Portland Retirement Residence - 830 Ocean Avenue

Ron has asked me to provide you with some additional clarification regarding the changes to our project. Attached is the change log that has been highlighted to reflect the items that are specifically code related along with a couple of additional that Ron feels you might want to just take a look at as well.

SHEET  
A6.3b

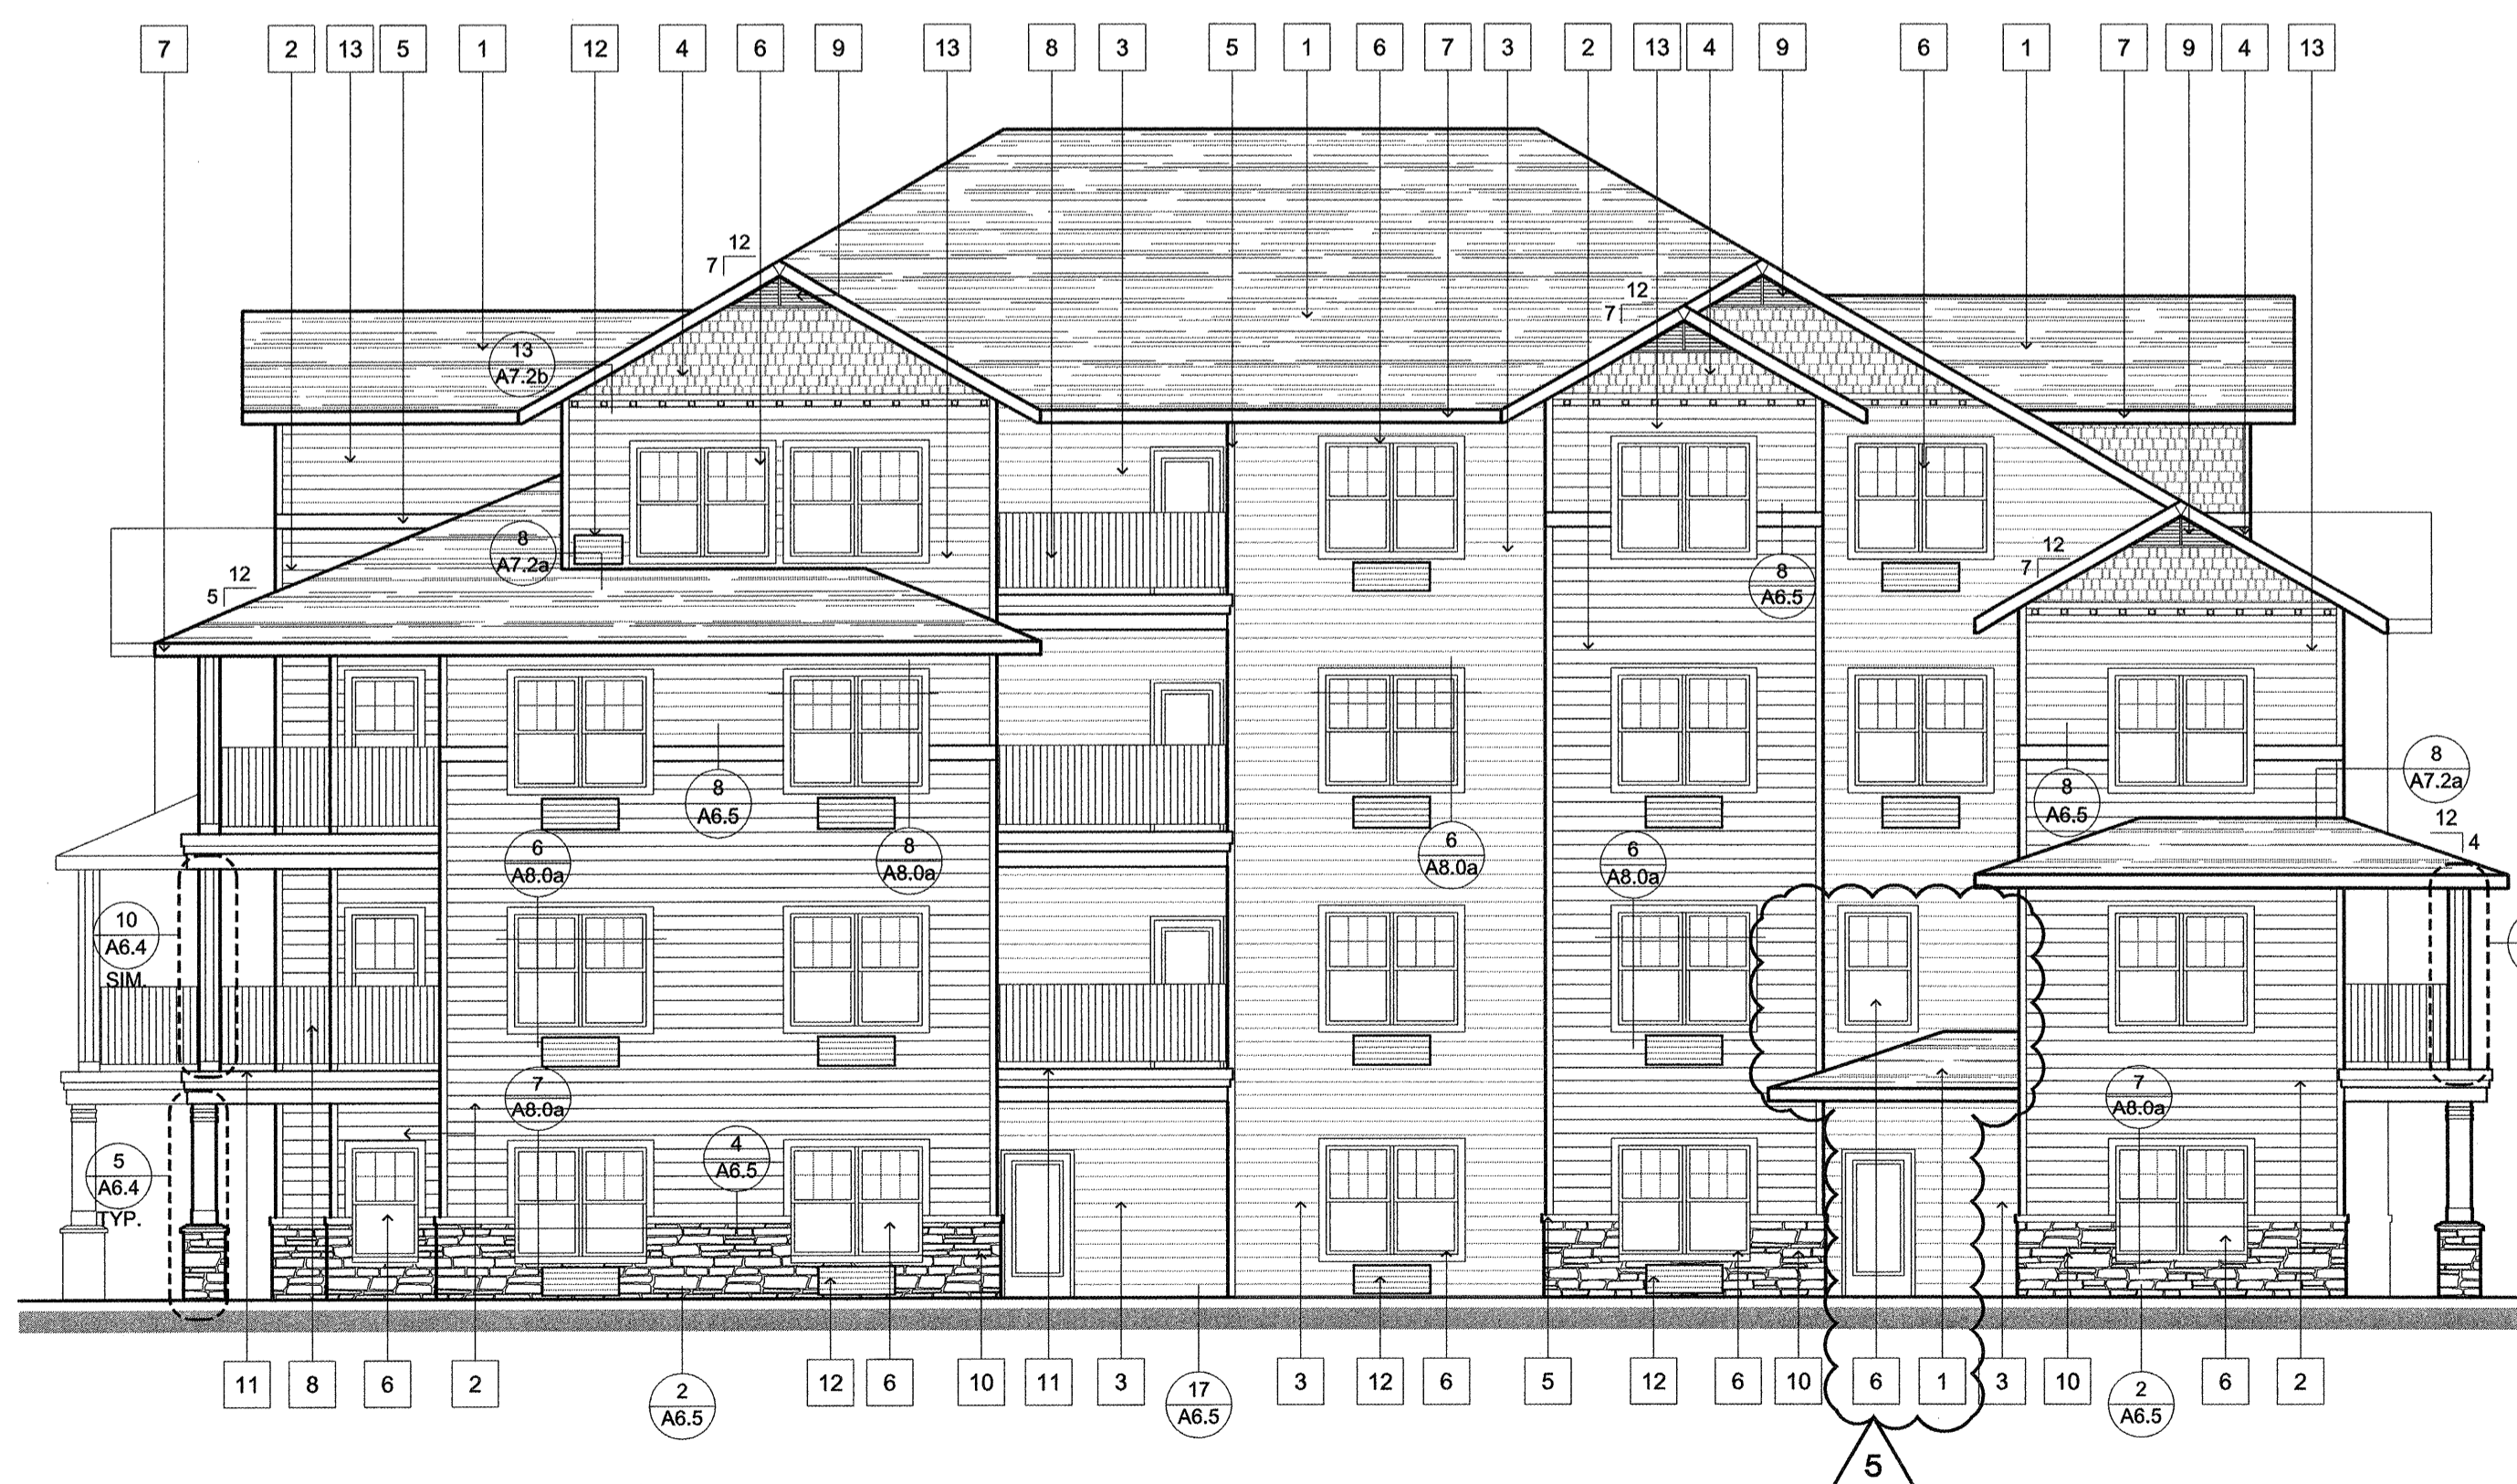
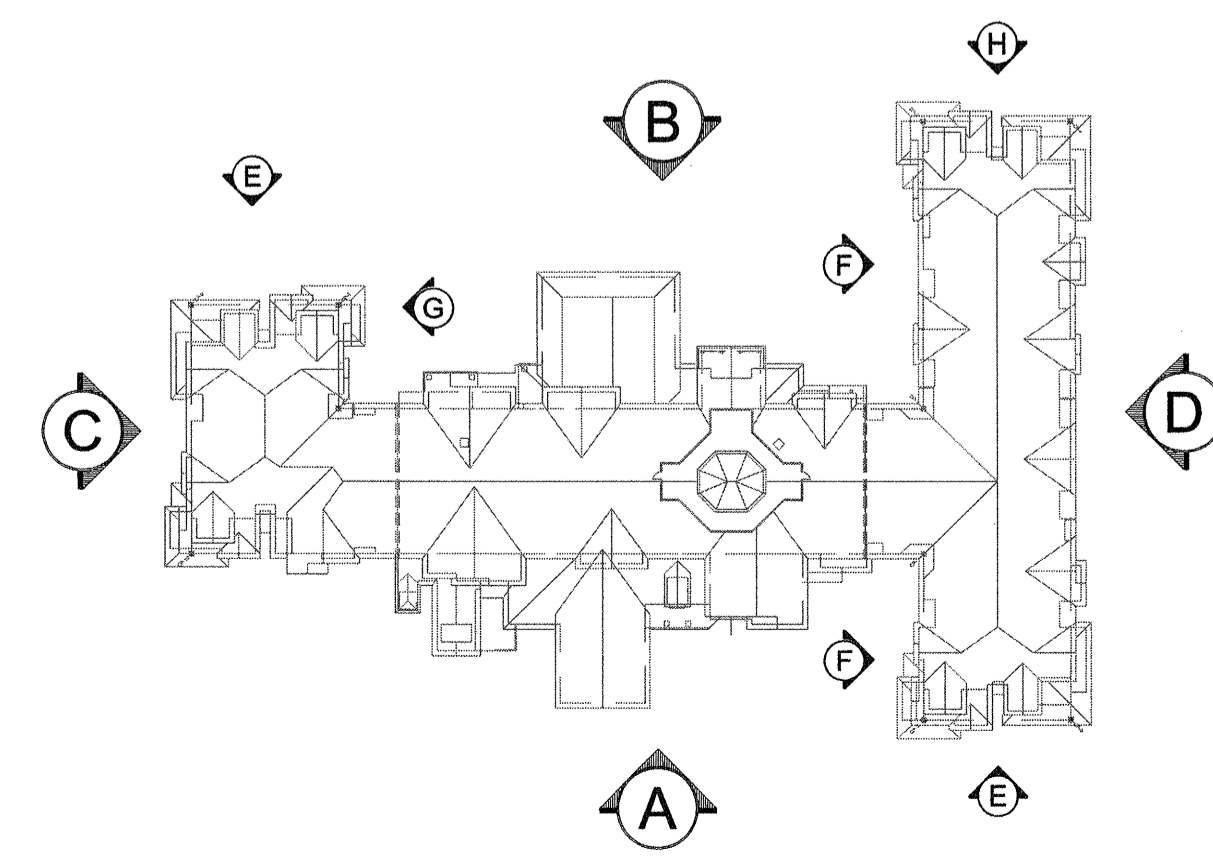
Please see attached site plan changes that reflect the removal of the carports. Please let me know if this is acceptable and how you would like me to provide the final stamped drawings. Ron asked that I let you know that there are no other exterior impacts other than the elevator room move and all associated elevations are on sheet A6.3b that we have already submitted.
